**WEST SUSSEX COUNTY COUNCIL
STRATEGIC PLANNING CONSULTATION**

SUBJECT: LU/32/17/PL - Demolition of existing dwelling & garage & erection of 4 No. dwellings with on-site parking & landscaping.

Sunnymeade, Courtwick Lane, Wick, Littlehampton, BN17 7PA

BLOCK PLAN
1:500

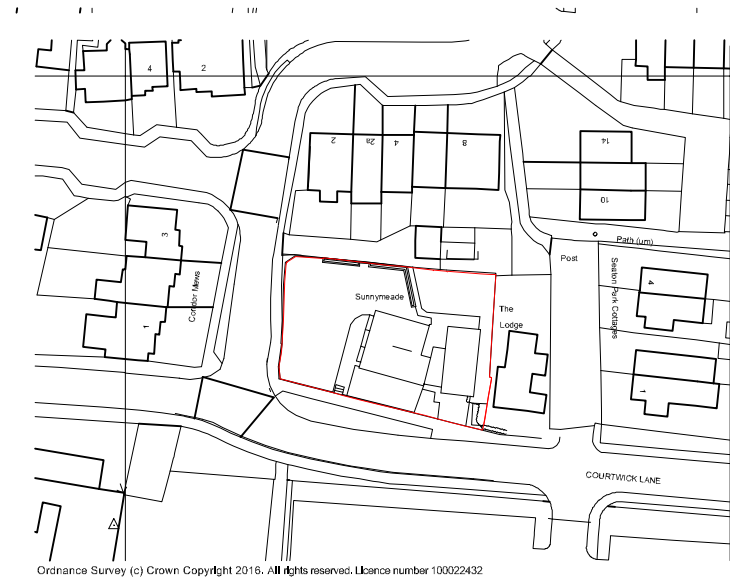
The existing VCO is sufficient to provide access to the one off-street car parking space for the detached dwelling. Two new VCO's are proposed from Condor Mews. A licence for these works on to the public highway should be obtained from WSCC Area Engineer.

There appears to be no apparent visibility issue on to Courtwick Lane or Condor Mews. Whilst the new VCO's will be in proximity to the junction the LHA consider that speeds will be low and traffic light. We do not foresee a highway safety concern with the introduction to a VCO in this location.

There is the opportunity to provide pedestrian visibility splays either side of the proposed and existing accesses, within the site, in order to maintain visibility of pedestrians on the adjacent footway. Details of this can be secured via condition.

One allocated off street car parking space per dwelling is proposed. On this basis the WSCC Car Parking Demand Calculator anticipates a demand of five spaces total for the terraced dwellings and two for the detached dwelling. There does appear to be additional space on the frontages to provide further off-street parking. However, the LHA would not raise a highway safety concern to this shortfall in parking provision.

A turn on site would be preferred, clearly though there is insufficient space to achieve this. However other properties have similar arrangements and balanced against this is the benefit of providing an opportunity to remove a vehicle that would otherwise be parked on the highway in a location where the existing practice is on-street parking by residents of adjoining properties which results in a noticeable narrowing of the existing available carriageway space.

No part of the development shall be first occupied until pedestrian visibility splays have been provided either side of the proposed site vehicular access onto Condor Mews and the existing access on to Courtwick Lane in accordance with plans and details submitted to and approved in writing by the Local Planning Authority. These visibility splays shall thereafter be kept free of all obstructions over a height of 0.6 metre above adjoining carriageway level or as otherwise agreed.
